GG119 ROAD SAFETY AUDIT RESPONSE REPORT

Project Title:	Woodward Court, Mirfield
Project Team:	Optima Highways and Transportation Ltd
RSA Report Stage	Stage 1
RSA Organisation:	Road Safety Initiatives
RSA Report Reference:	RSI-MM-0626-006 Issue 1.0
RSA Report Issue Date:	1 st July 2026
Report Title:	Response to Woodward Court, Mirfield, Stage 1 Road Safety Audit
Reference:	260706 Woodward Court, Mirfield – RSA Stage 1 Response Report

This Road Safety Audit Response Report relates to a Stage 1 Road Safety Audit carried out in Mirfield on the proposed residential development access junction in Hepworth Lane, a residential access in Woodward Court and associated improvements in Wellhouse Lane (Planning Application Reference 2025/93355). The objective of the scheme is to provide access to a development of up to 75 residential dwellings. Full details of the scheme can be found within the Road Safety Audit Brief dated 17/06/2026.

Image 2.3 Proposed Hepworth Lane Site Egress

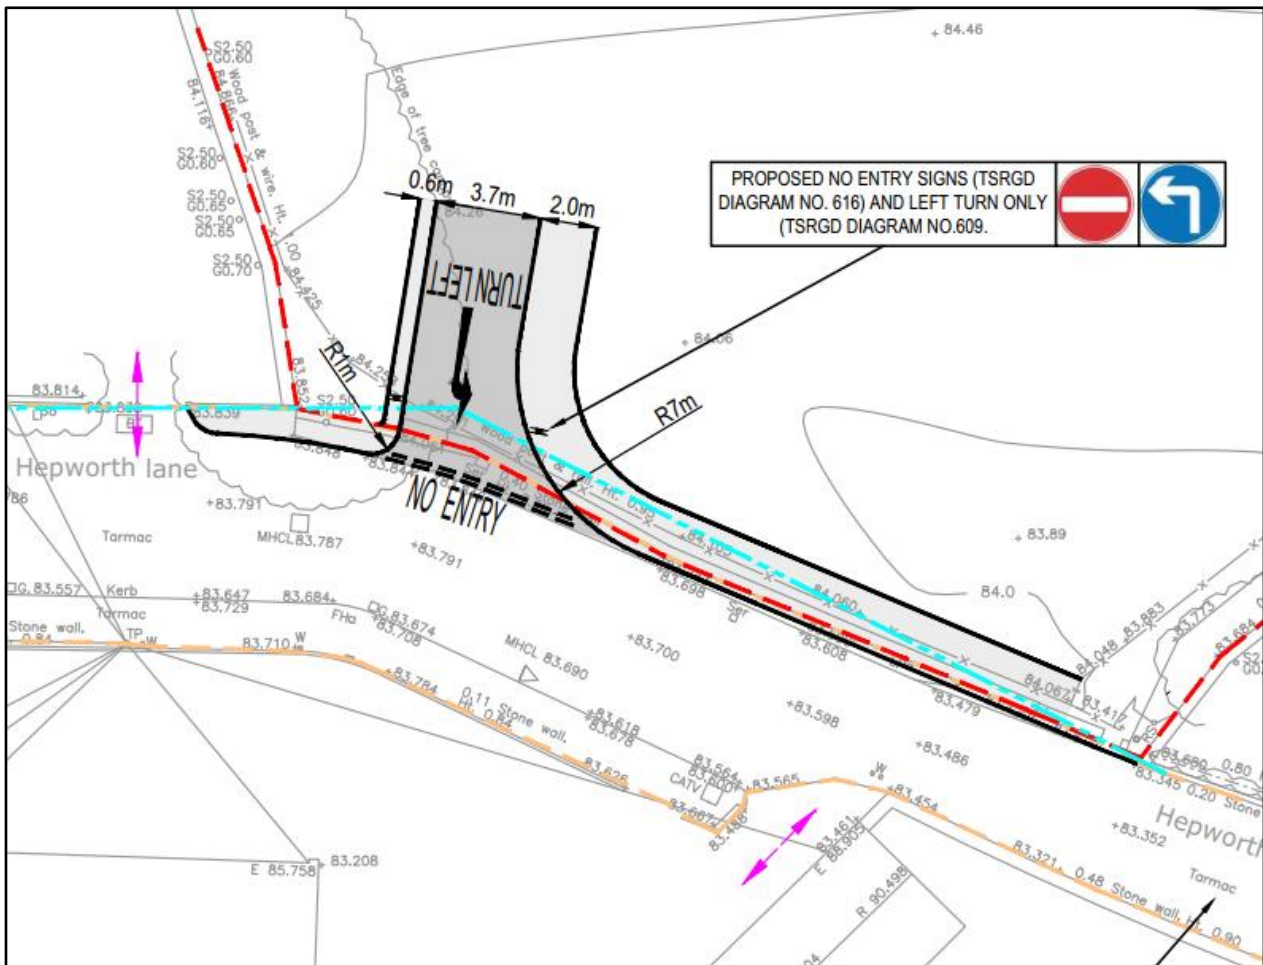
Location: Proposed residential development access junction in Hepworth Lane.

Summary: Conflicts associated with restricted geometry for vehicles turning right from the access junction.

Detail: Parked vehicles opposite the proposed junction will cause cars turning right out to be on the wrong side of the road, possibly leading to a head-on conflict. In addition, delivery vehicles turning right out may struggle to complete their manoeuvre, possibly leading to conflicts associated with reversing or the overrunning of kerb.

It is recommended that on-street parking is prohibited opposite the new junction

Recommendation is not accepted and is unnecessary for the following reasons:

- Drivers turning right out of the development access would naturally look in both directions before entering Hepworth Lane and would therefore be able to observe any approaching vehicles. Visibility splays have been provided in accordance with the relevant standards and are supported by the speed survey data. The eastbound 85th percentile speed was recorded at 18 mph, requiring a visibility splay of 2.4 m × 22 m, while the westbound 85th percentile speed was 21.7 mph, requiring a visibility splay of 2.4 m × 28 m (ATC speed survey undertaken between 23/09/25 and 29/09/25). A worst-case visibility splay of 2.4 m × 28 m has been applied in both directions.

- The swept path analysis shown on drawing 25033/ATR/04 would not materially change if the on-street parking opposite the junction was removed, as the geometry and alignment of Hepworth Lane govern the vehicle tracking rather than the presence of parked vehicles.

The RSA Problem is only partially accepted (the element relating to large vehicles turning right), and the RSA recommendation is rejected. The Design Team Response is accepted, with the following additional points noted:

- As confirmed in the Design Team response, adequate junction visibility is to be provided in both directions. Therefore, head-on collisions would not be caused by parked vehicles opposite the junction. Should parking occur to the west of the junction, this could potentially result in right turning vehicles being forced to travel in the off-side lane. However, this is not anticipated to be a frequent occurrence and would be a typical situation in a residential street. Therefore, it has been agreed with the Highway Safety team that on-street parking control measures are not considered necessary at this time.

- As confirmed in the RSA Brief, the right turn movement from the minor arm is not possible by the Kirklees Design Refuse vehicle (but is possible by light vehicles, fire tenders and other smaller emergency service vehicles). However, this is not necessary, as there are alternative routes that can be used by refuse/service vehicles (e.g. the existing bin collection route via Woodward Court, or by turning left from the site egress onto Hepworth Lane). Therefore, it has again been agreed with the Councils Highway Safety team that on-street parking control measures are not considered necessary at this time, as right turn movements by large vehicles are not anticipated (or would be an extremely rare occurrence).

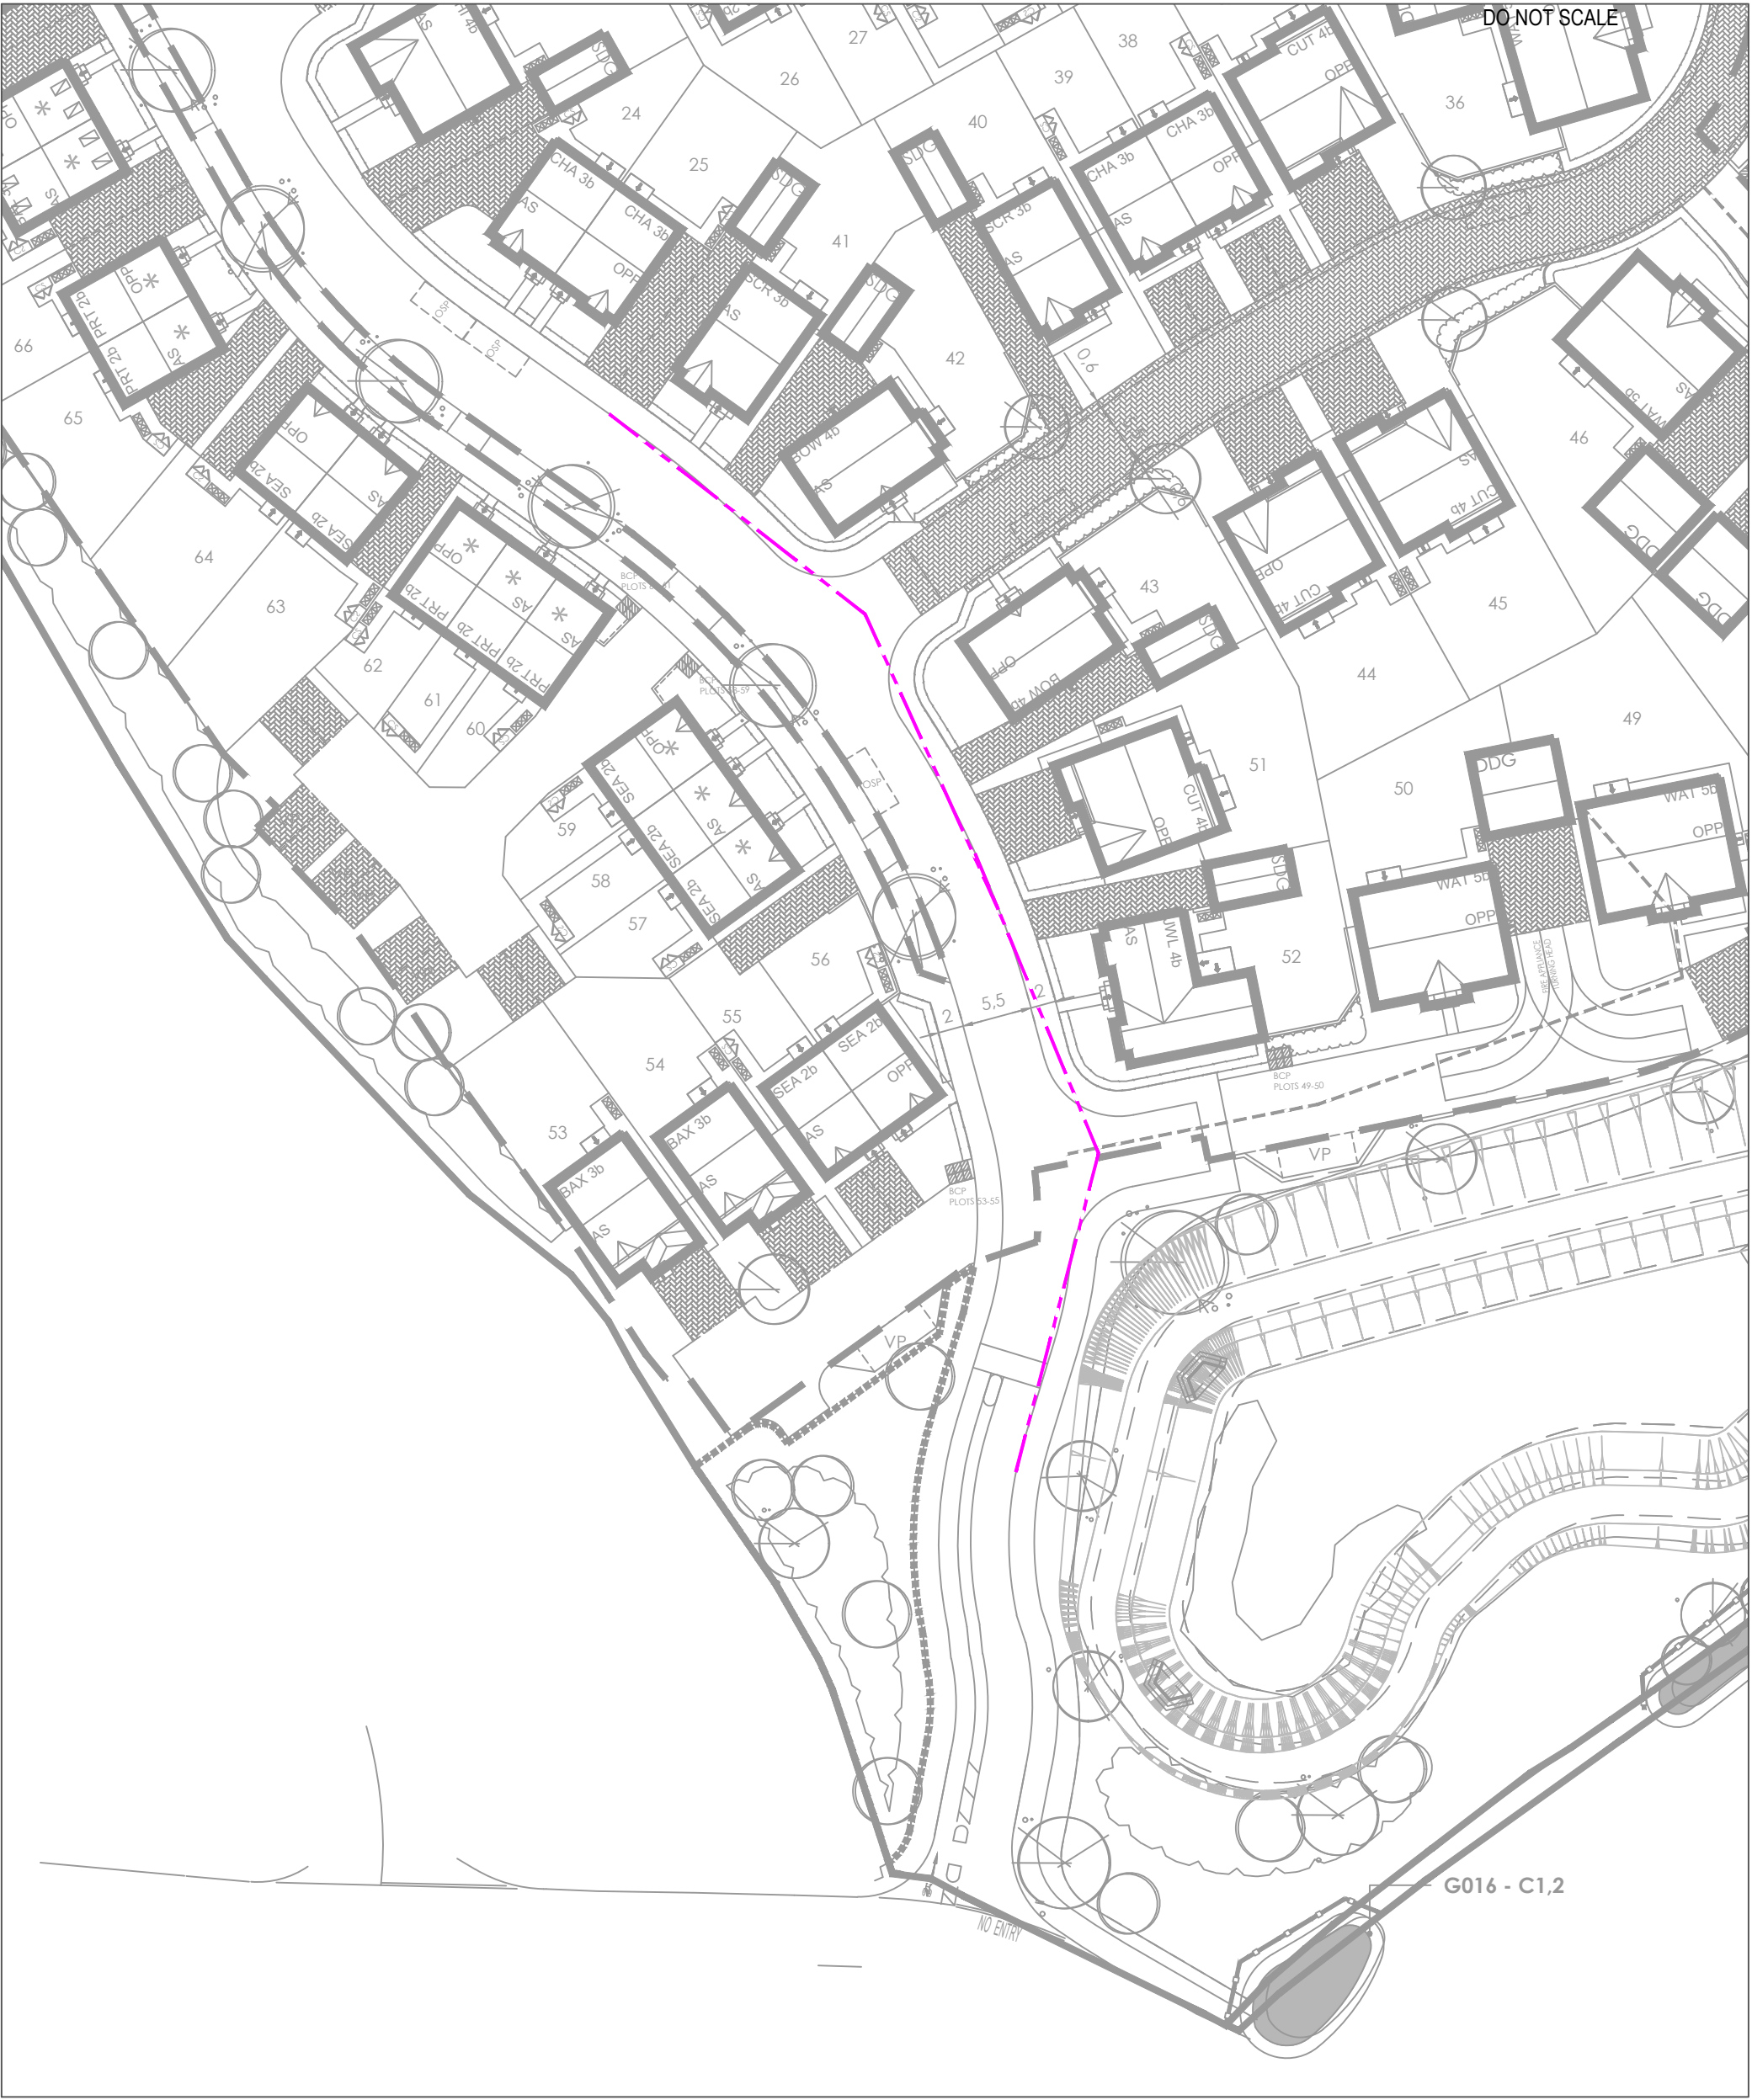
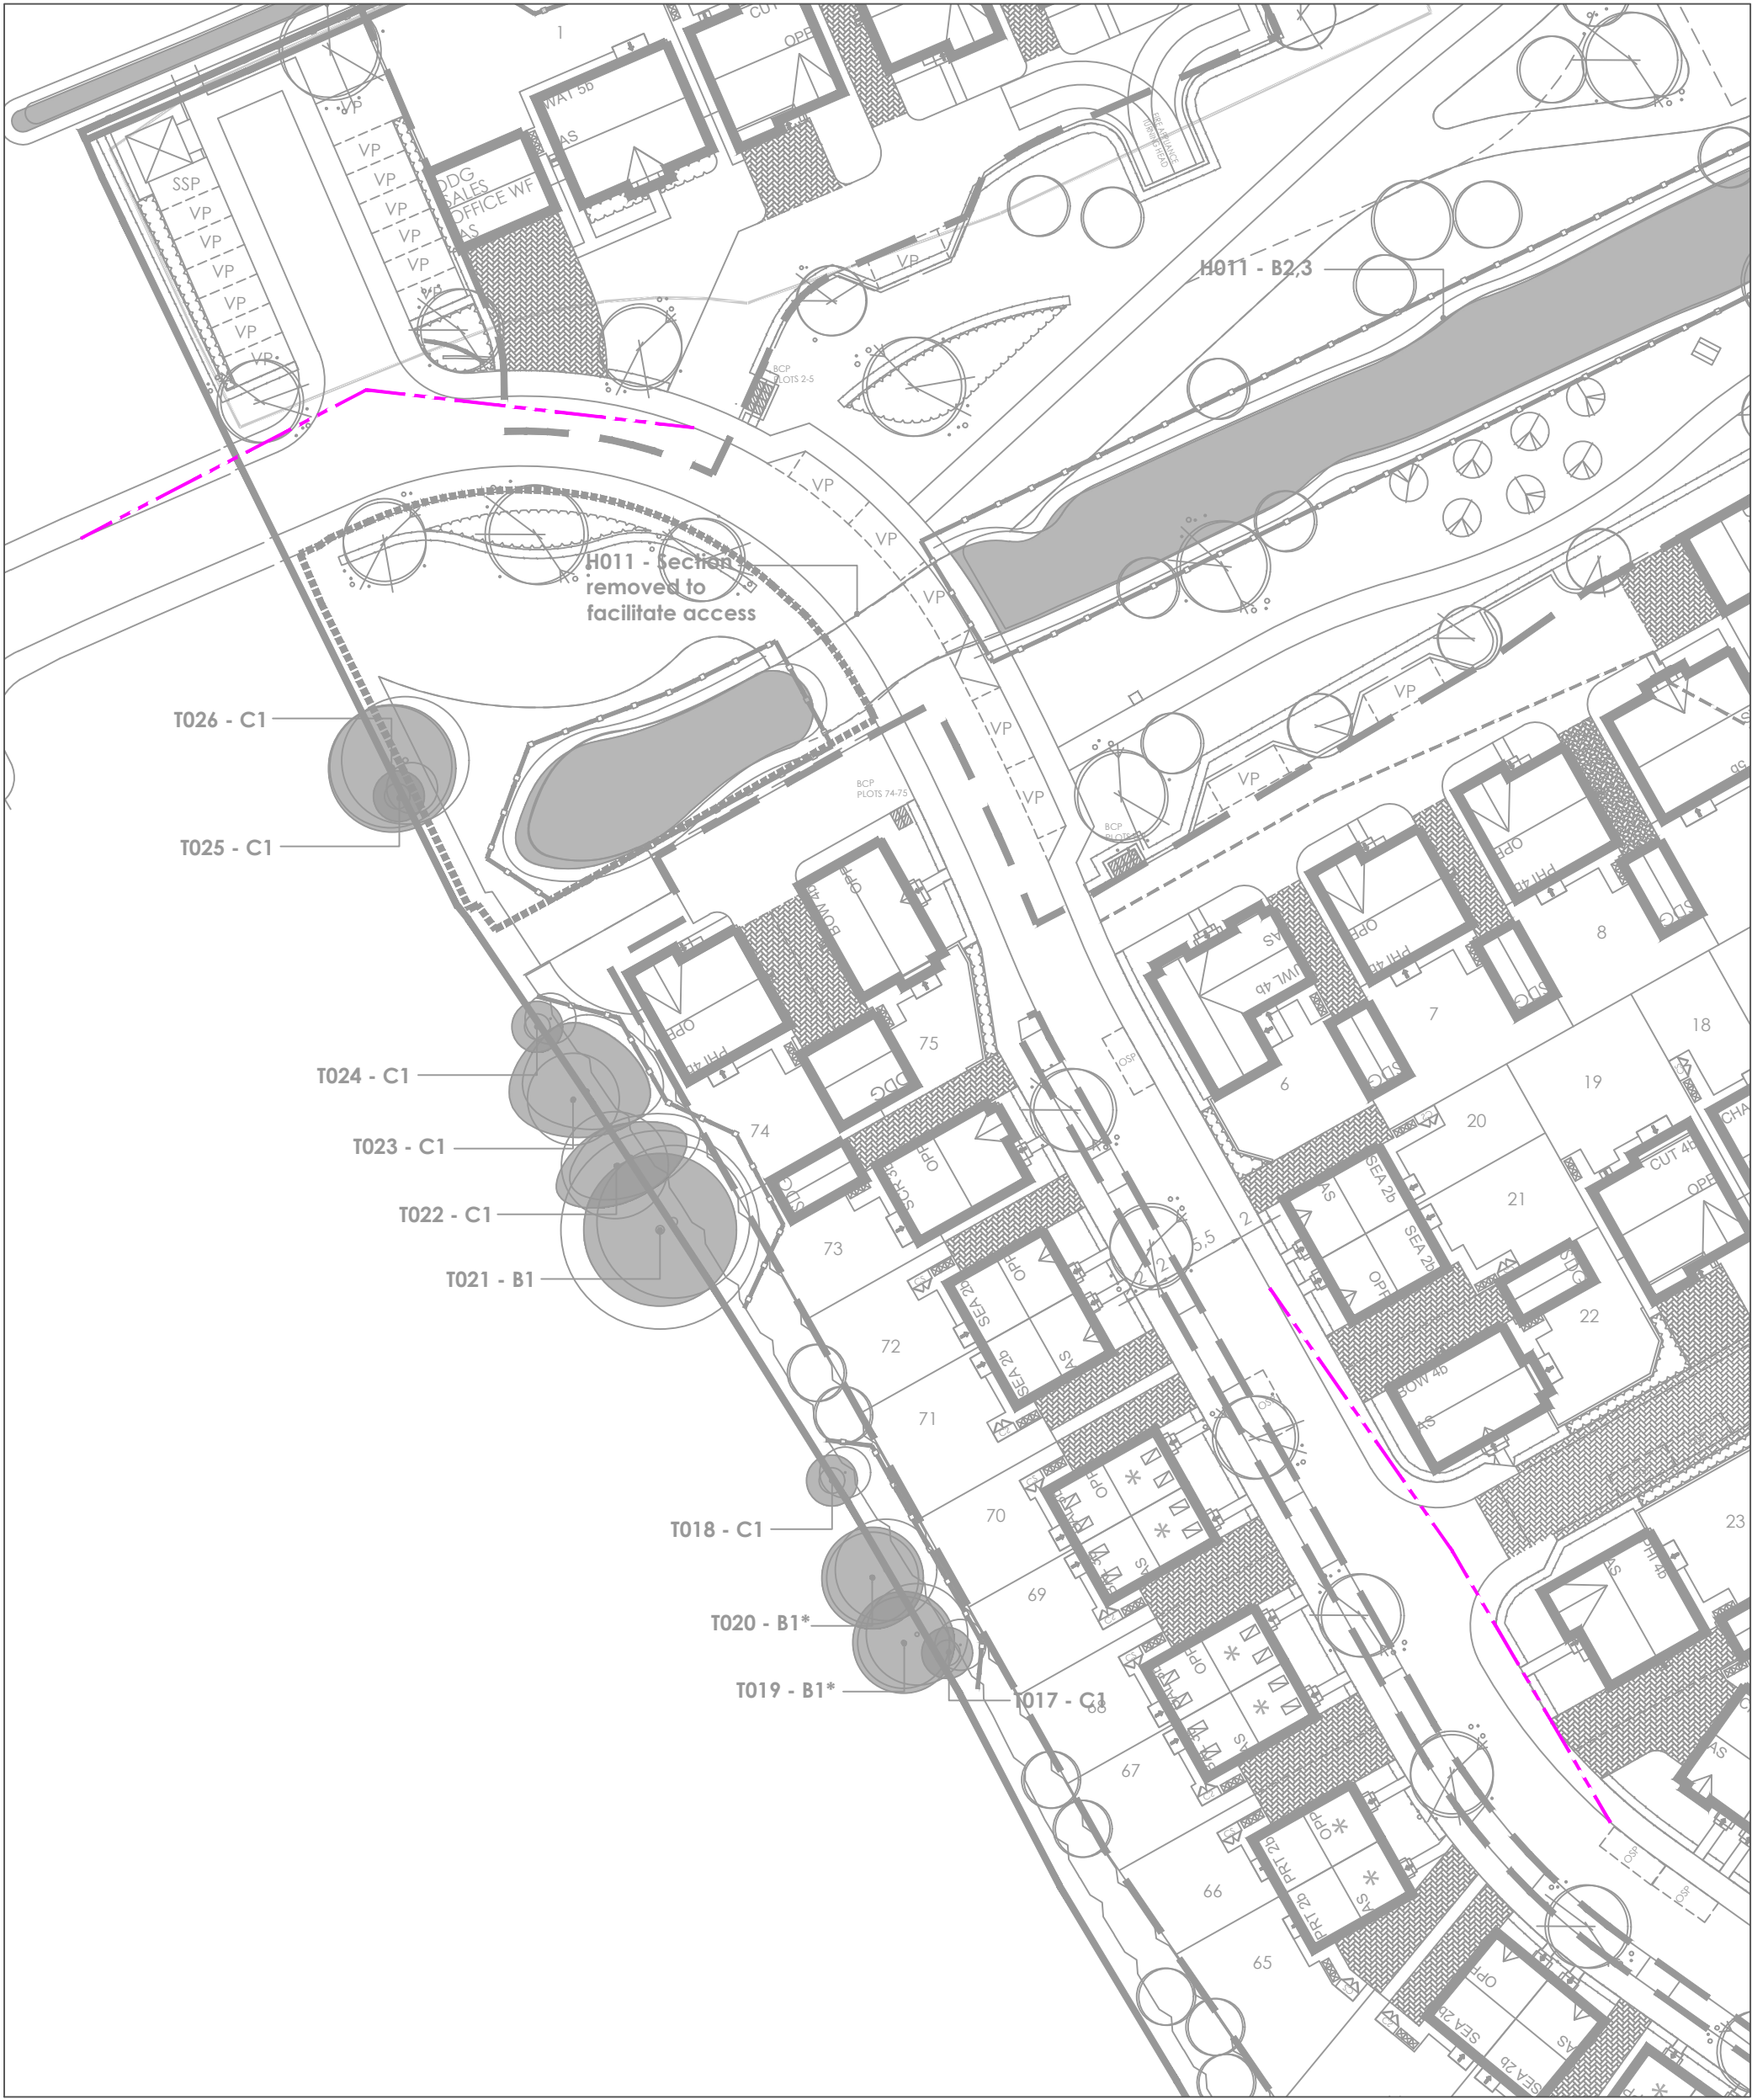
Location: Woodward Court Extension

Summary: Potential for 'vehicle-to-pedestrian' incidents associated with restricted visibility.

Detail: Following the proposed extension of Woodward Court, visibility from an existing drive (7 Woodward Court) may be inadequate, because there is a close-boarded fence. Conflicts involving vehicles emerging and people / traffic from the new estate are possible.

Recommendation: It is recommended that adequate visibility is achieved. This could be achieved by realigning the carriageway or by land purchase or by removal of part of the boundary fence.

In accordance with *Manual for Streets (MfS)*, a setback of 2.4m from the edge of the carriageway can achieve a 25m visibility splay, which is appropriate for a 20mph speed limit.

MfS also recognises that a reduced setback of 2.0m may be acceptable in lightly trafficked, low-speed environments, stating:

“A minimum figure of 2m may be considered in some very lightly-trafficked and slow-speed situations, but using this value will mean that the front of some vehicles will protrude slightly into the running carriageway of the major arm. The ability of drivers and cyclists to see this overhang from a reasonable distance, and to manoeuvre around it without undue difficulty, should be considered.”

The RSA Problem is accepted, and the RSA Recommendation is partially accepted. The Design Team response is accepted, which confirms that adequate visibility will be available to/from the private drive with a set-back distance of 2m, which is adequate in this situation.
